Subject: Planning Application 2026/60/91494/E, Penistone Road, Birdsedge - Issues with the Flood Risk Assessment and Drainage Strategy

On reading the Flood Risk Assessment and Drainage Strategy for the above application by the consultant AMA Associates, I noted the following:

Test Reference: SA01

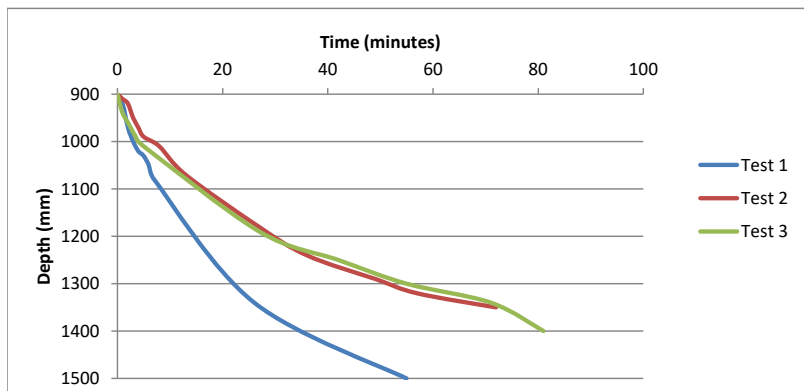
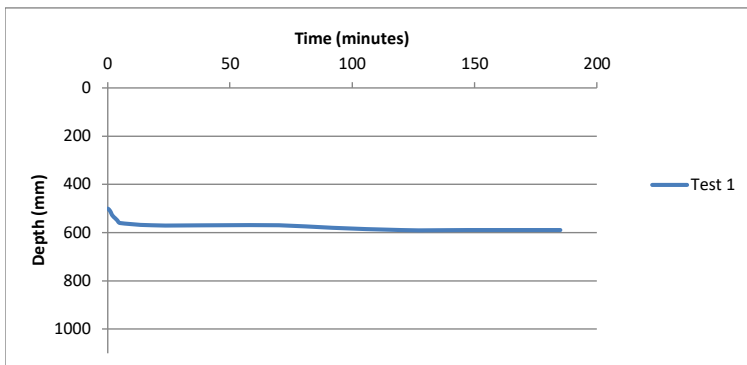
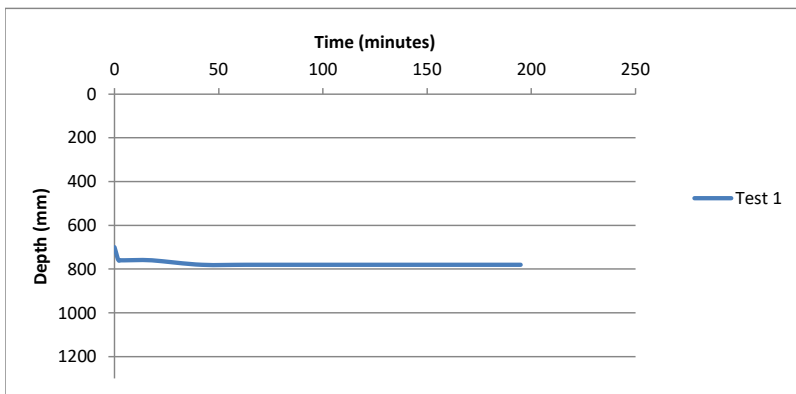
1. I see that the sub-consultant report from Eastwood (Appendix F), where 3 infiltration tests were done, but only one was successful. The report states:

“ The infiltration rates recorded in SA01 suggest that soakaway drainage may locally be a viable form of surface water drainage. However, due to the much lower rates recorded in SA02 and SA03, it appears that infiltration drainage may not be possible in all areas of the site. It is recommended that further testing is undertaken to determine which areas of the site can provide suitable infiltration rates, if the use of infiltration drainage is to be pursued. It may be prudent also to test the shallower, more weathered soils to see if shallow infiltration features such as swales or permeable paving could be considered.”

The size of the infiltration test pits was 0.8m x 2.1m each, surely this is an insufficient number of trial pits for a site which covers 3.17 hectares. Are you able to request from the Applicant that this additional work that the sub-consultant recommended is carried out?

Appendix I
Drainage Layout Drawing

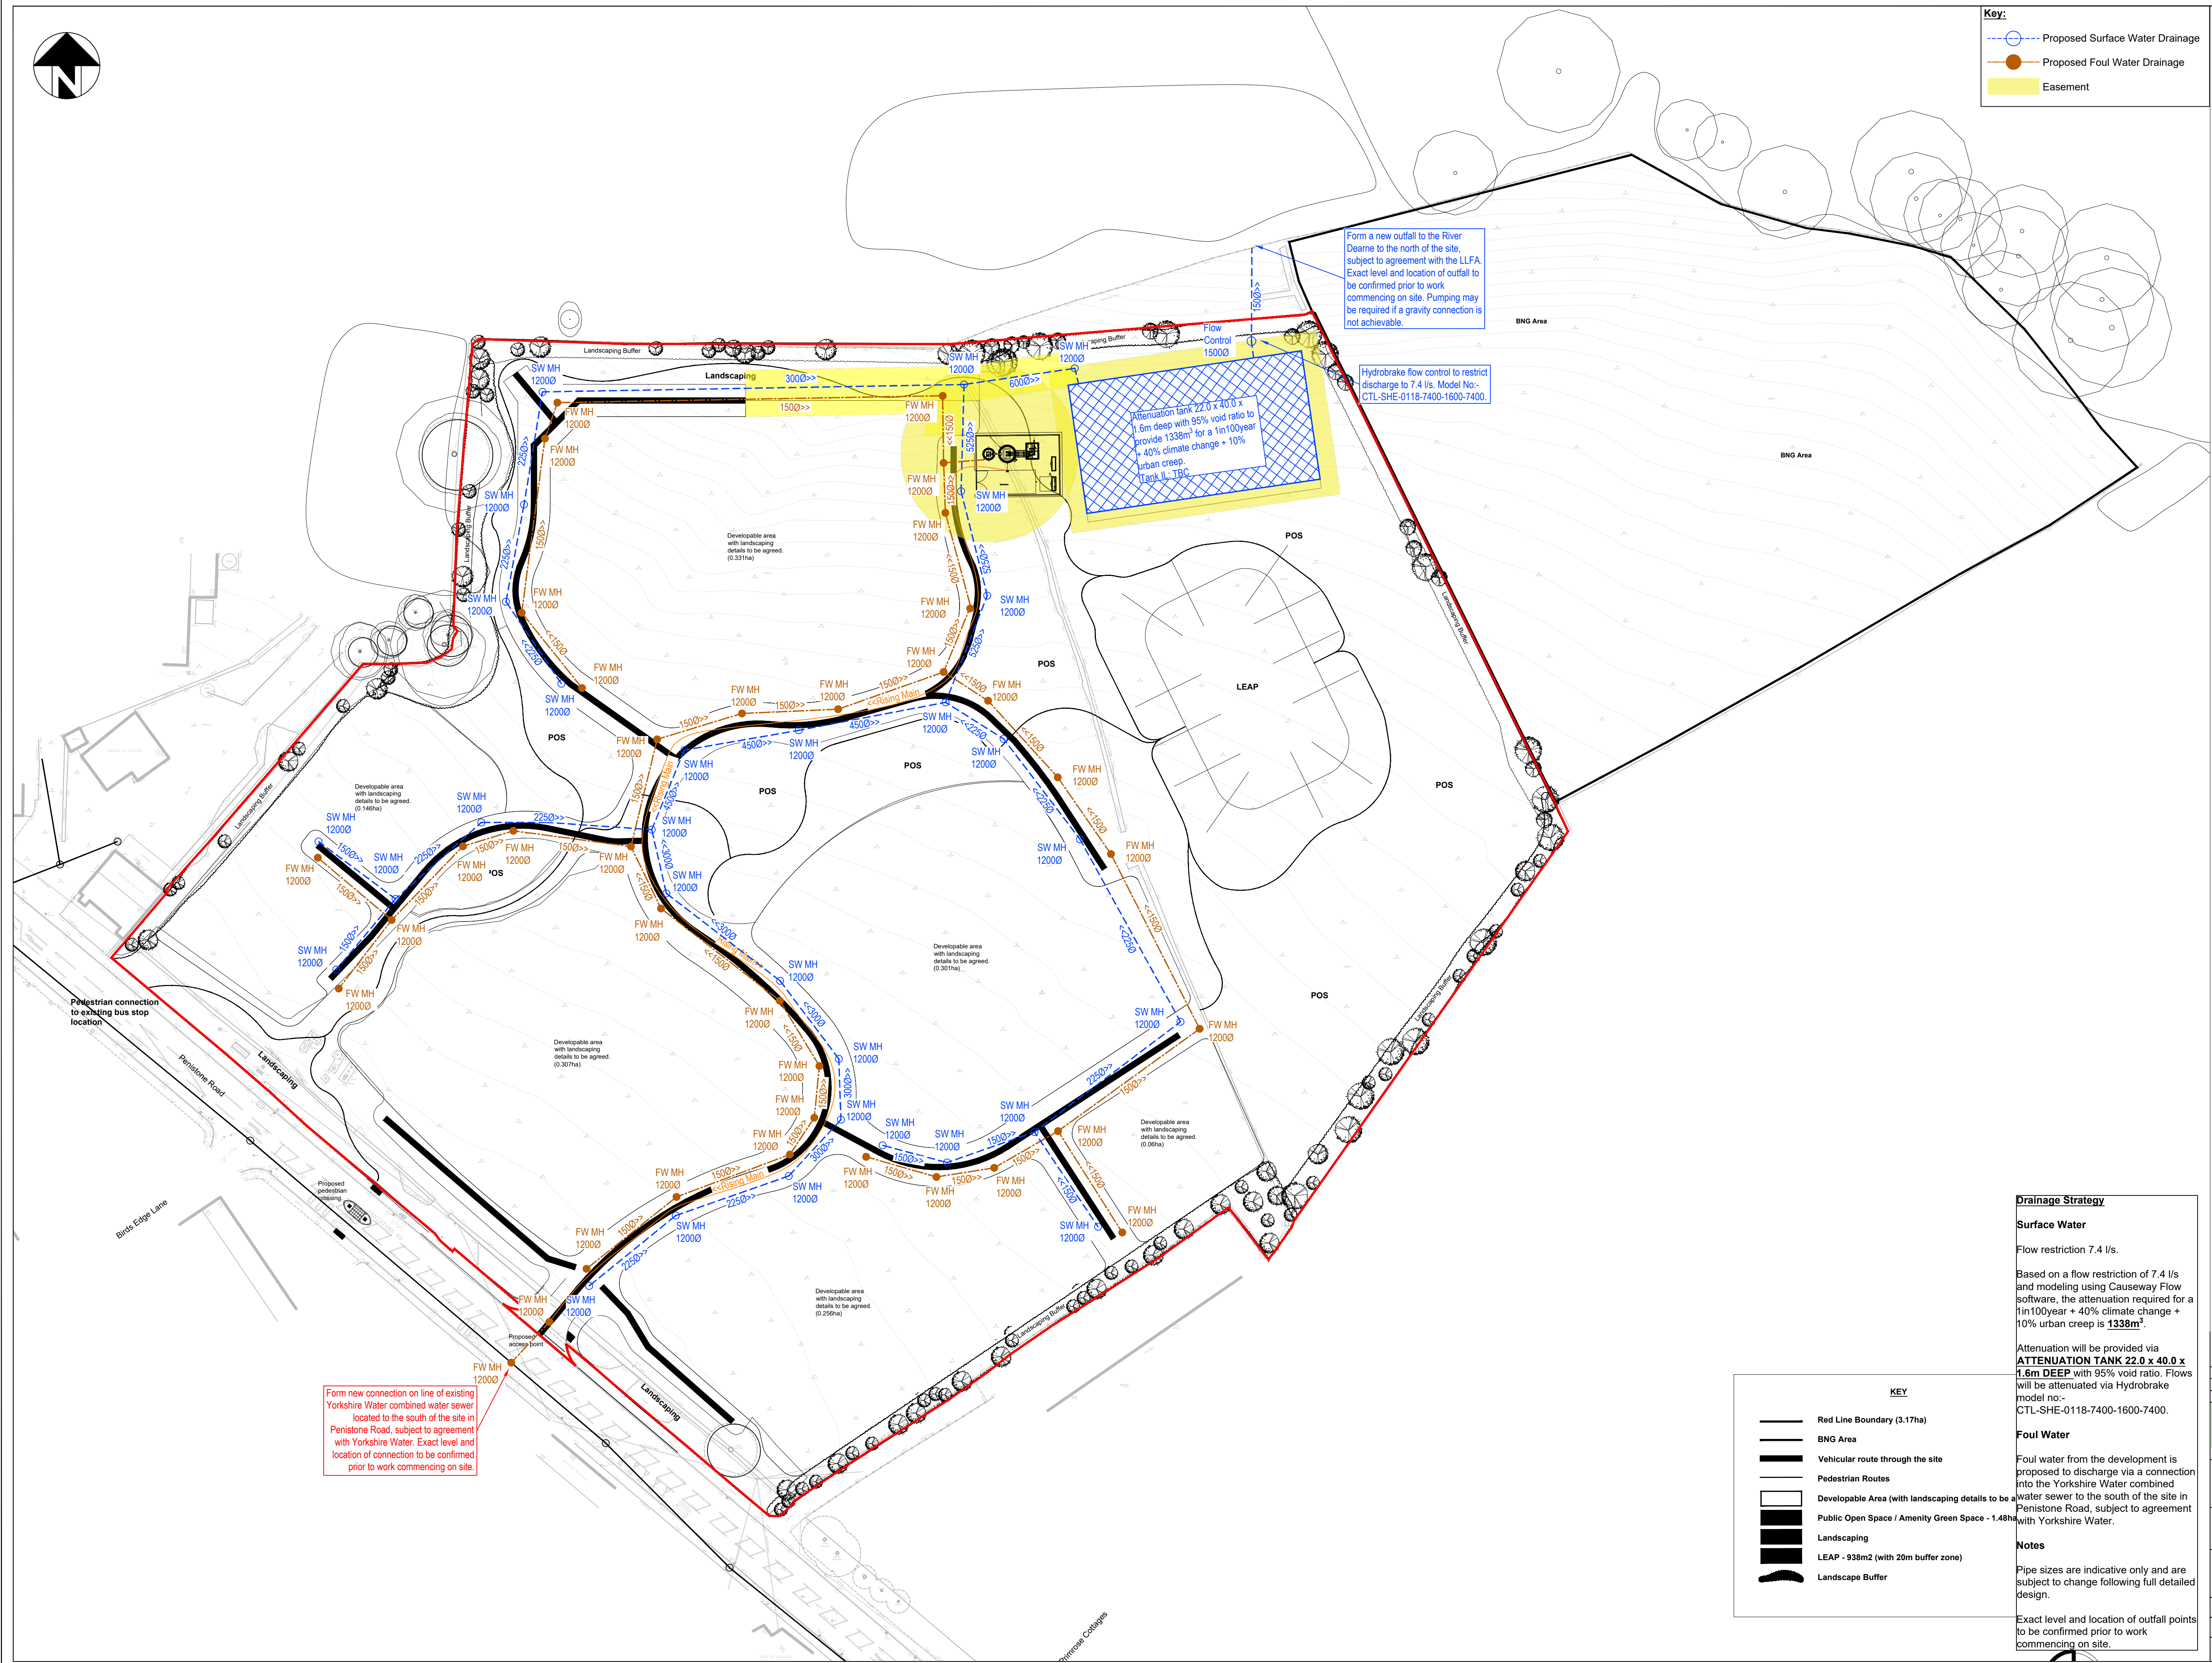
“As such, infiltration methods are not deemed to be viable.”

“The developer's attention is drawn to Requirement H3 of the Building Regulations 2010. This establishes a preferred hierarchy for surface water disposal. Consideration should firstly be given to discharge to soakaway, infiltration system and watercourse in that priority order.”

So that would suggest that the consultant has chosen the worse of these options.
